DEVELOPMENT HEARING OFFICER

PR-2024-009768

SD-2024-00117 - PRELIMINARY/FINAL PLAT
IDO – 2022 SKETCH 4-17-24 (DFT)

CONSOLIDATE 2 LOTS INTO ONE NEW LOT

PLAT OF
LOT 3-A, BLOCK 1,
LANDS OF THE ATRISCO GRANT
(REPLAT OF LOTS 3 AND 4, BLOCK 1,
LANDS OF THE ATRISCO GRANT)
TOWN OF ATRISCO GRANT,
PROJECTED SECTIONS 28 AND 29,
TOWNSHIP 10 NORTH, RANGE 2 EAST
N.M.P.M.
CITY OF ALBUQUERQUE,
BERNALILLO COUNTY, NEW MEXICO
JUNE, 2024

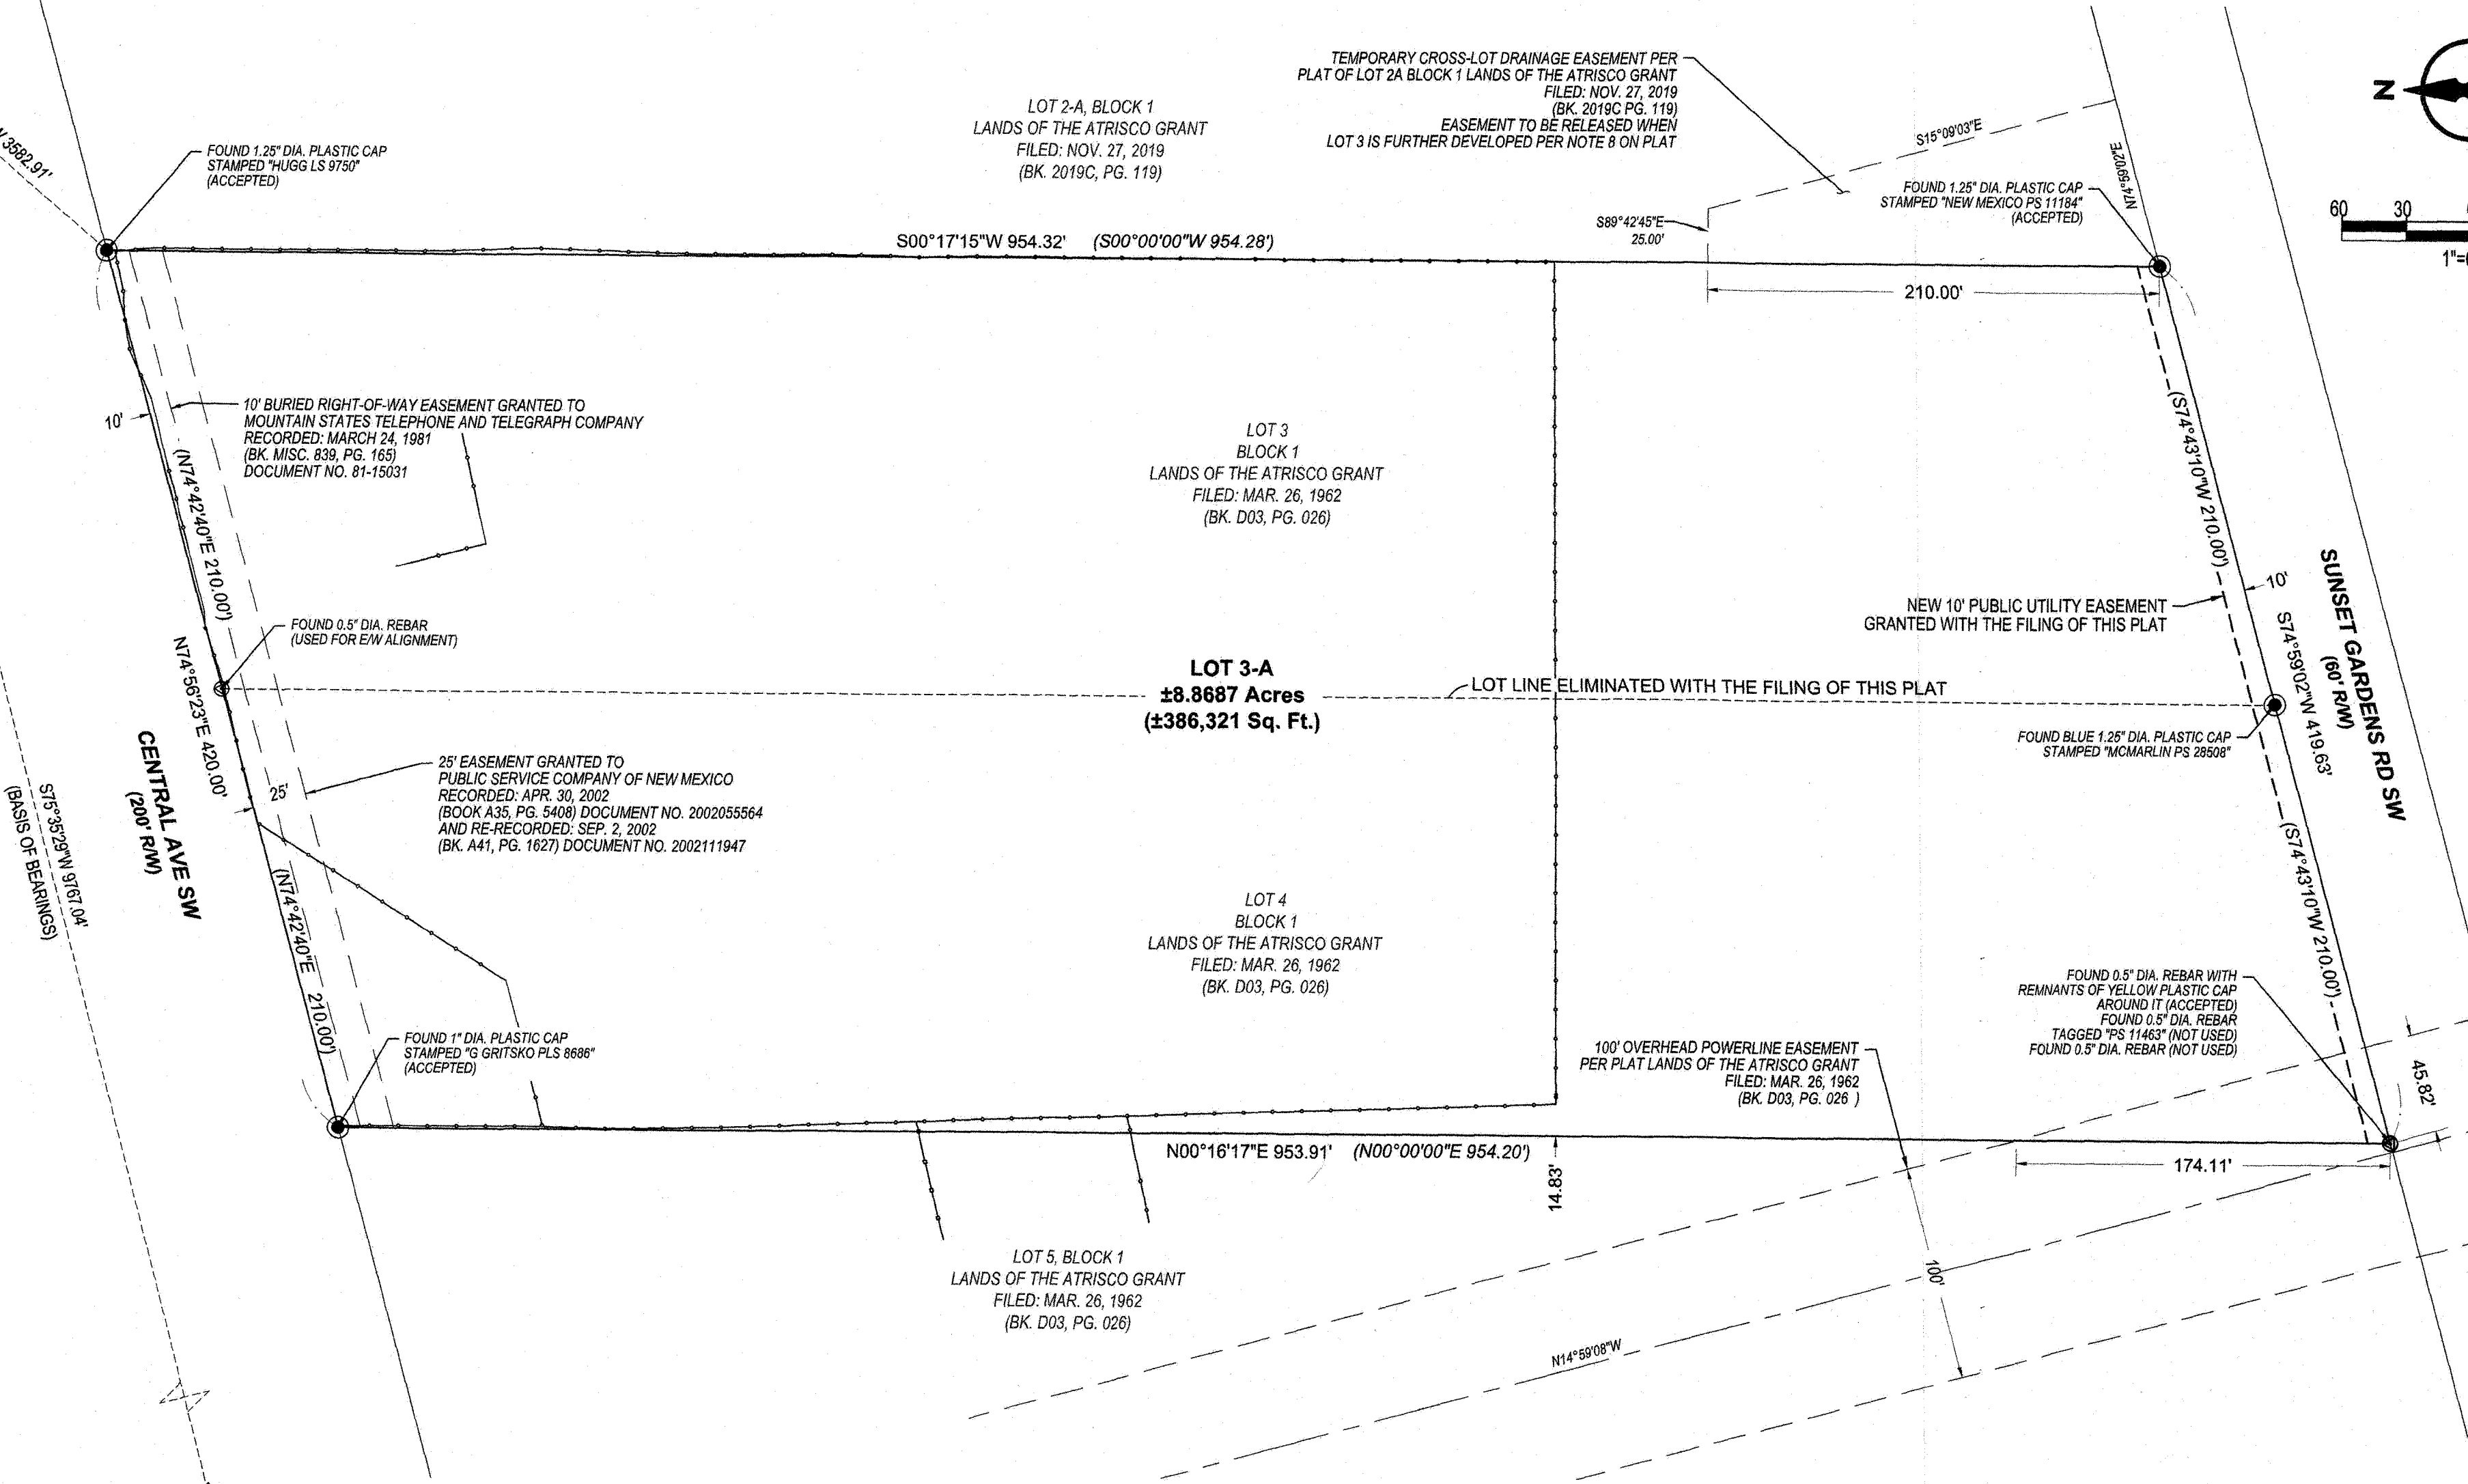
- Application number must be added to the plat.
- Confirm that the Infrastructure List is tied to the Site Plan Administrative DFT application. A recorded IIA based on the Infrastructure List approved with the Site Plan DFT application needs to be submitted before the final sign-off of the plat.

- Prior to final sign-off of the plat, the AGIS office must approve the DXF file and proof of approval must be provided.
- Per 6-6(L)(2)(d)(7) of the IDO, the date of the DHO approval shall be recorded on the Plat. Therefore, prior to final sign-off of the Plat, the date of the DHO approval must be added to the Plat.
